**T-MOBILE SITE NUMBER:** DN06266A  
**T-MOBILE SITE NAME:** CO46077-A  
**T-MOBILE PROJECT:** SPRINT RETAIN

**SBA SITE ID:** CO46077-A  
**SITE ADDRESS:** 20359 INDUSTRY AVE. FOUNTAIN, CO 81008  
**JURISDICTION:** EL PASO COUNTY

TITLE SHEET

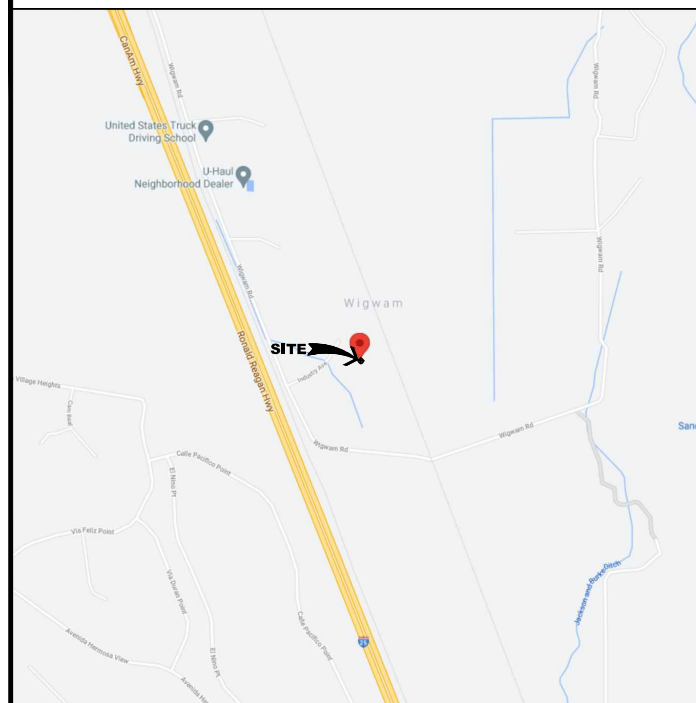
Add property legal description and tax schedule parcel #

Add PCD File # PPR-2174 to all sheets
